WEST SUSSEX COUNTY COUNCIL CONSULTATION

TO:	Arun District Council FAO:Mr S Davis
FROM:	WSCC - Highways Authority
DATE:	7 July 2022
LOCATION:	8 Gossamer Lane Aldwick PO21 3AY
SUBJECT:	AW/104/22/PL 1 No bungalow including parking, boundary fence, and alterations to entrance wall and driveway. This application may affect the setting of listed buildings and is in CIL Zone 4 and is CIL Liable as a new dwelling.
DATE OF SITE VISIT:	n/a
RECOMMENDATION:	Advice
S106 CONTRIBUTION TOTAL:	n/a

Drawing
Location, Site, Floor Plans

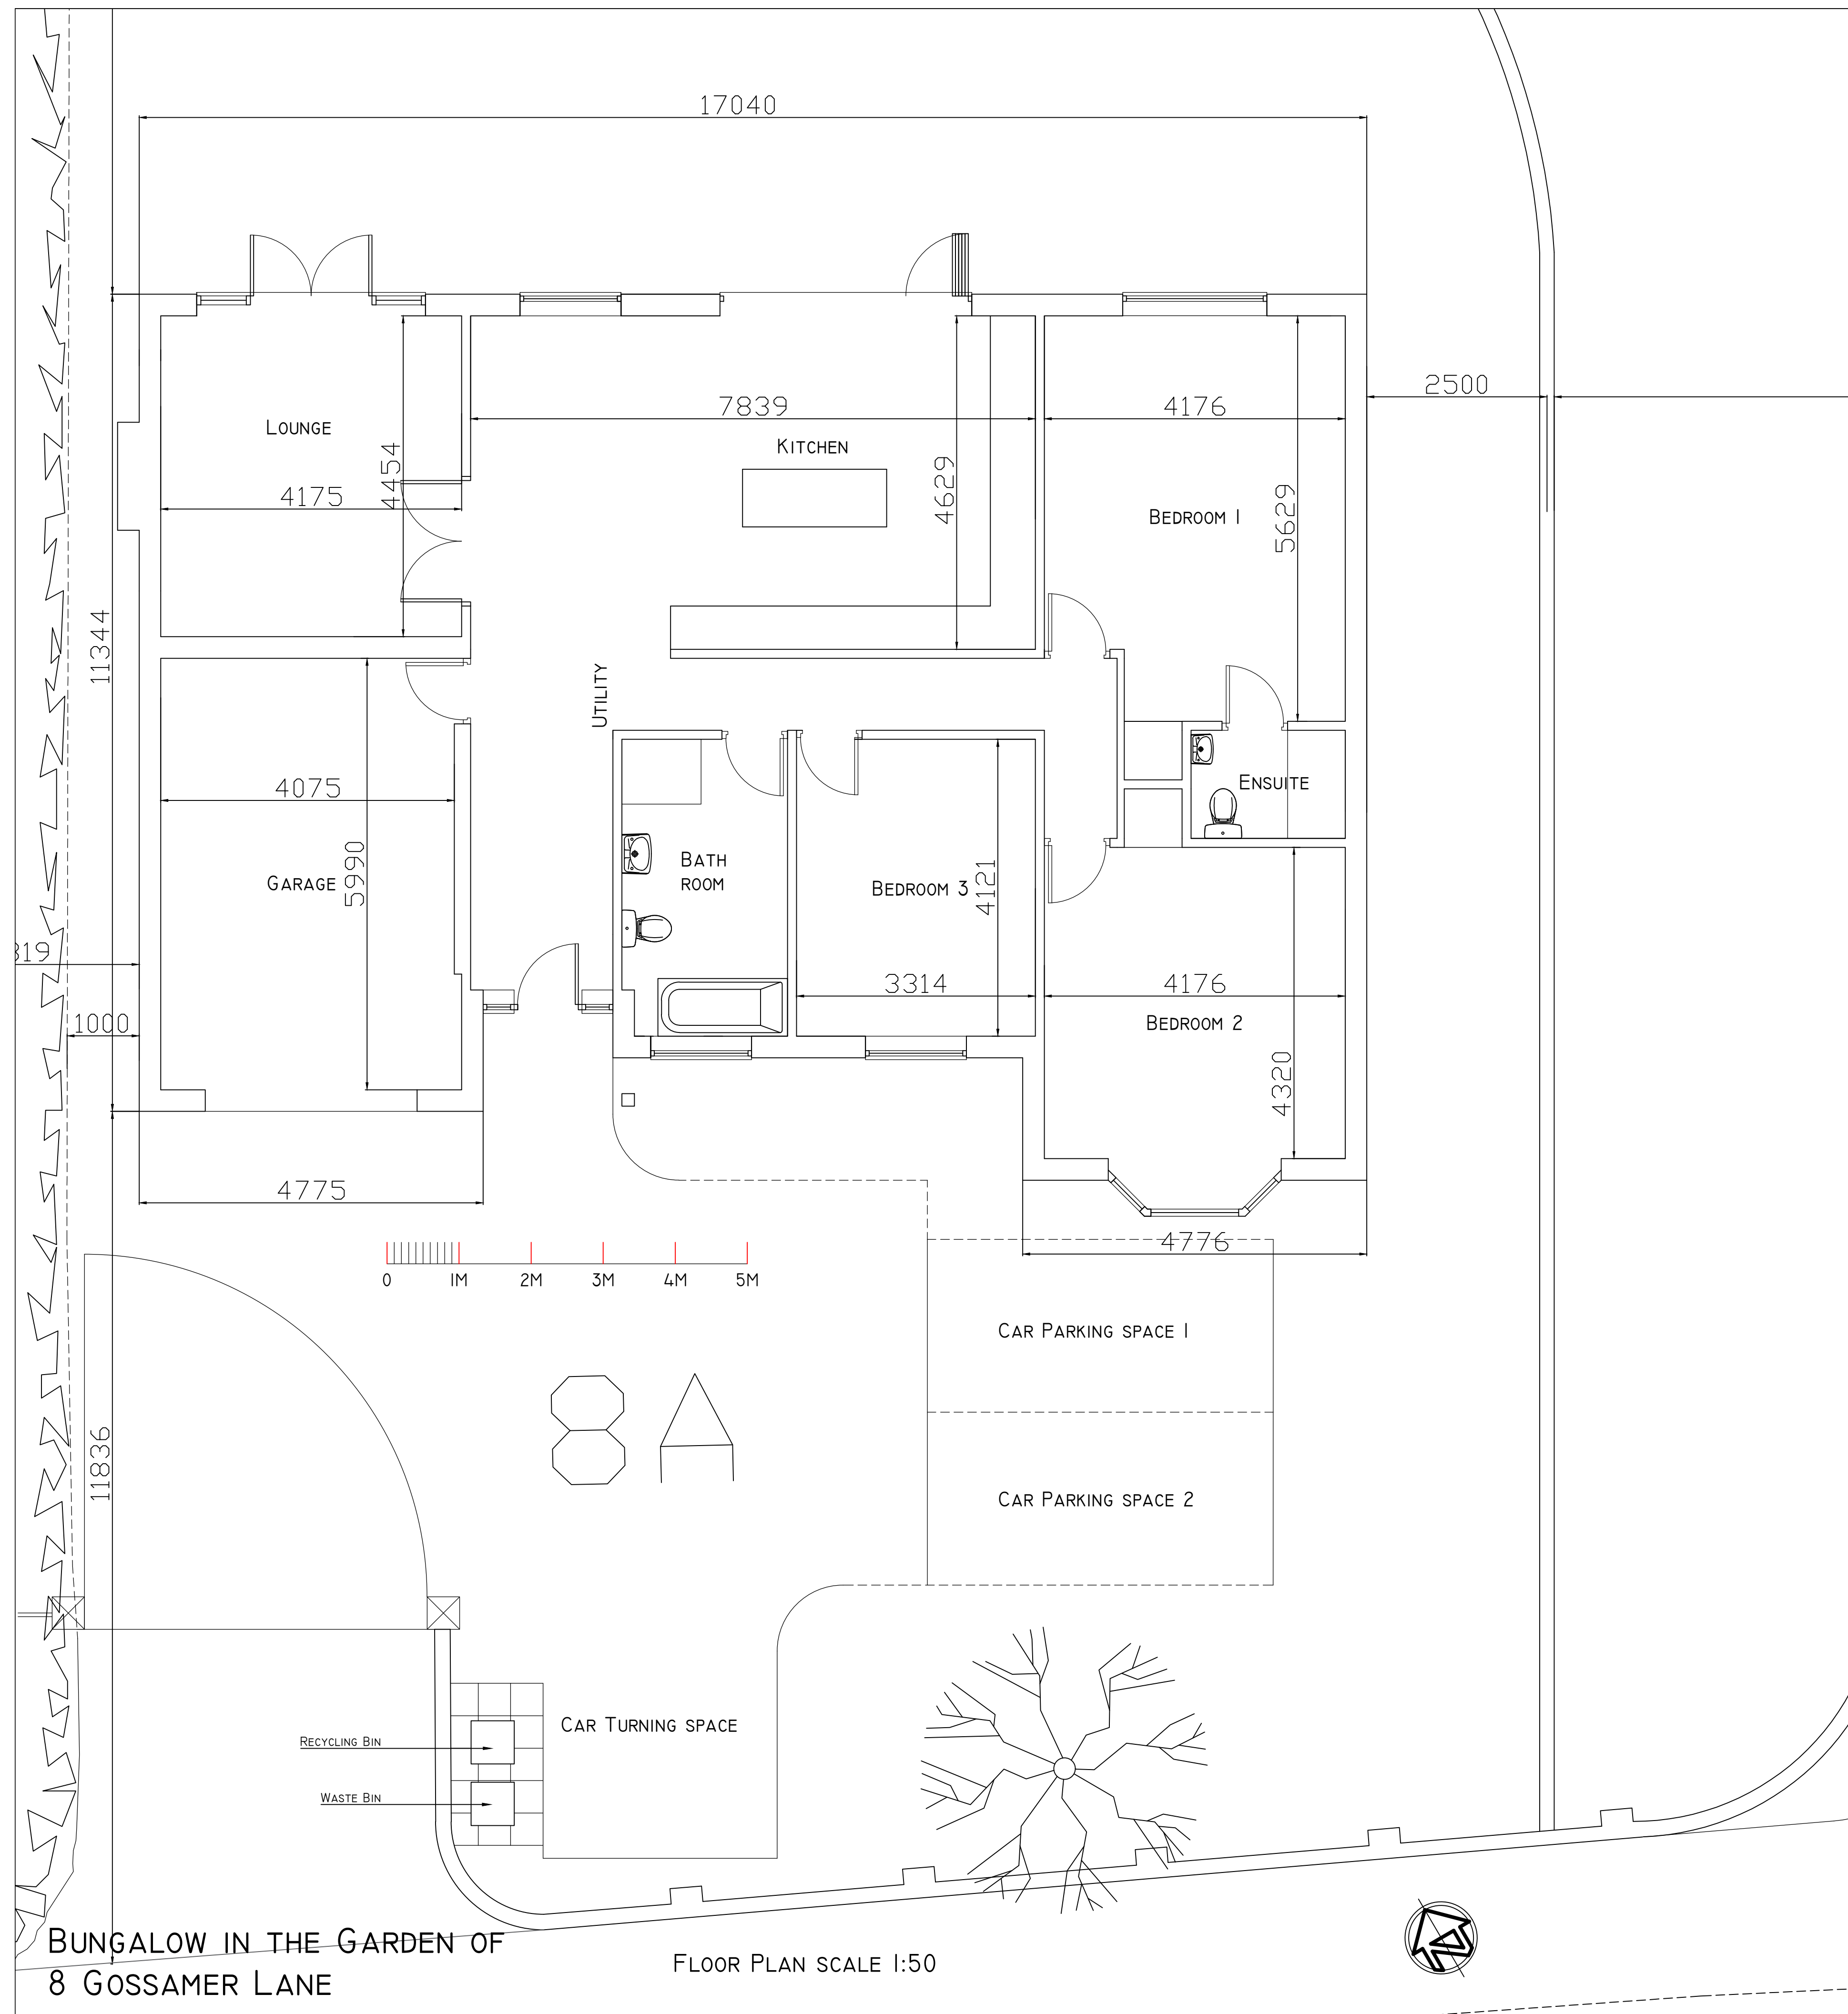
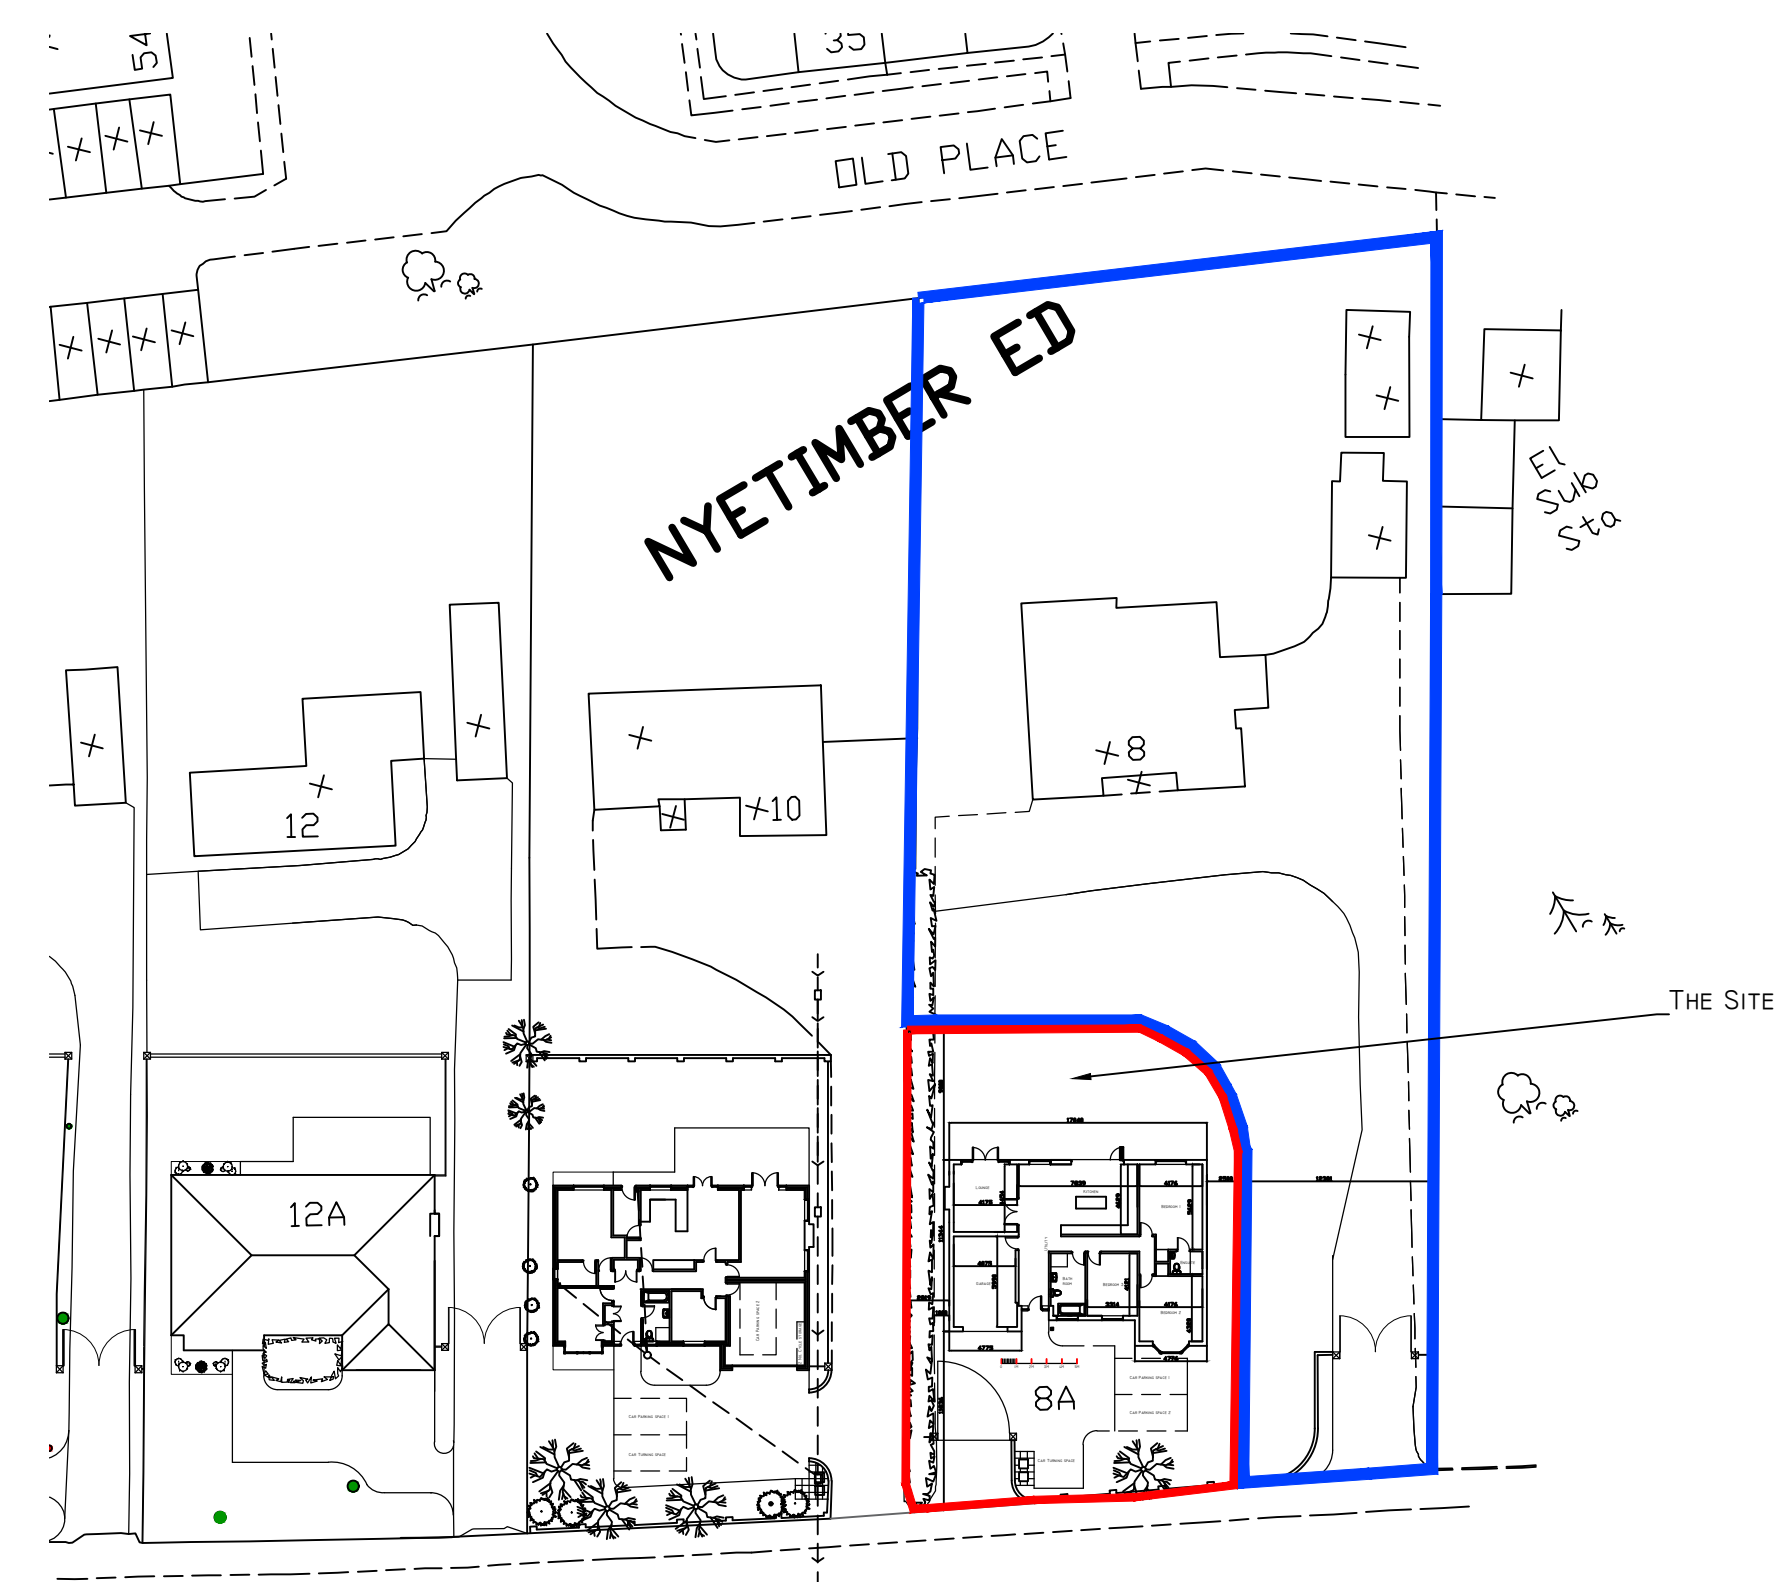
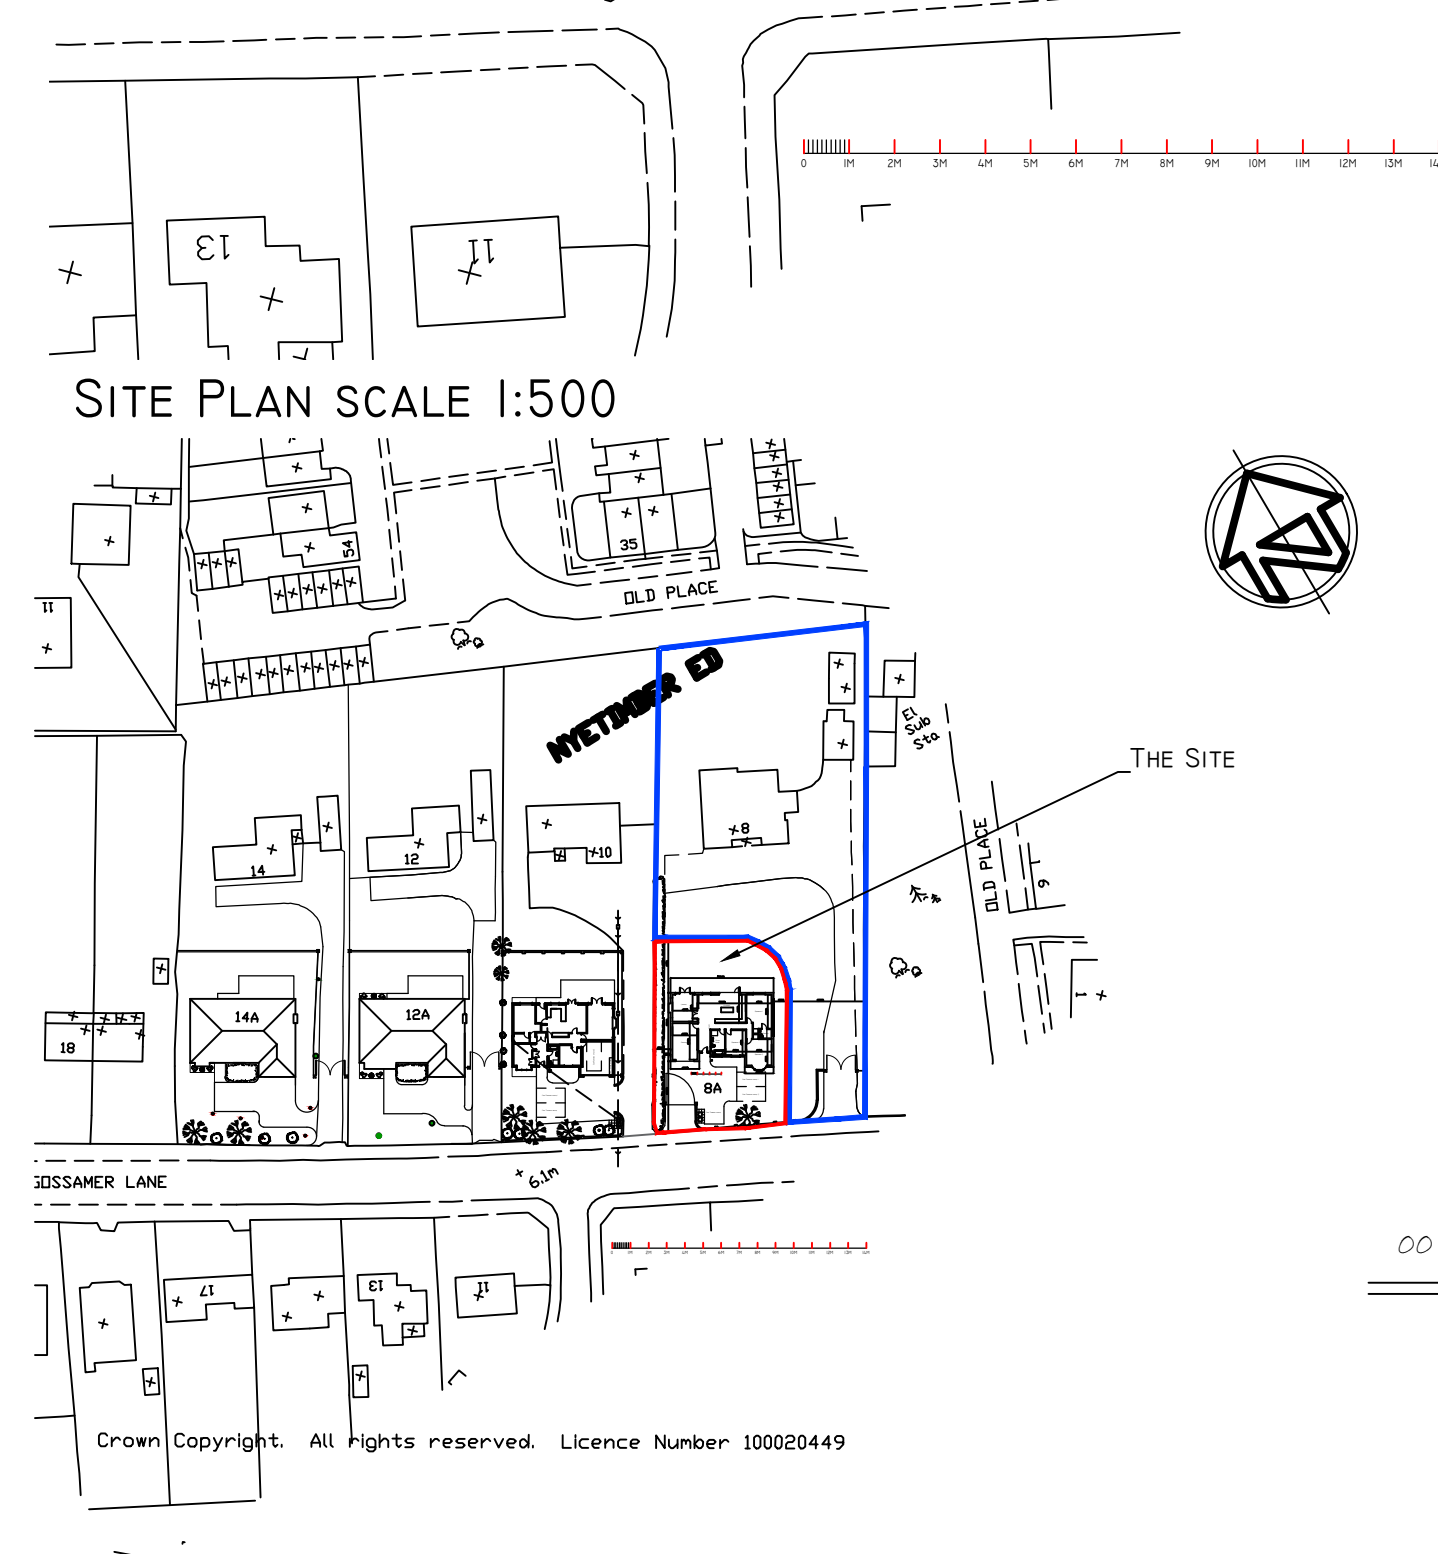
The proposed site plan demonstrates 3 parking spaces for this development, of which one is to be situated within the proposed garage. The WSCC Car Parking Demand Calculator (PDC) would expect 2 parking spaces to be provided for 2 bedroom dwelling in this location.

The proposed single garage, as demonstrated on the site plan 4x6m internally which accords with minimum requirement for a single garage of 3 x 6m as outline in Manual for Streets (MfS) guidance. It should be noted that under the revised WSCC parking guidance, each garage space (3 x 6m) counts as 0.5 of a parking space towards the expected provision.

Each parking bay accords with the minimum requirements of 2.4 x 4.8m.

The site's curtilage area for the proposed dwelling provides turning space for vehicles to turn and egress in forward gear onto the public highway.

In order to promote the use of sustainable transport methods, the LHA would advise cycle storage for the proposed dwelling. This can be situated within the proposed garage.

No part of the development shall be first occupied until the car parking spaces have been constructed in accordance with the approved site plan. These spaces shall thereafter be retained at all times for their designated purpose.

No part of the development shall be first occupied until covered and secure cycle parking spaces have been provided in accordance with the approved site plan.
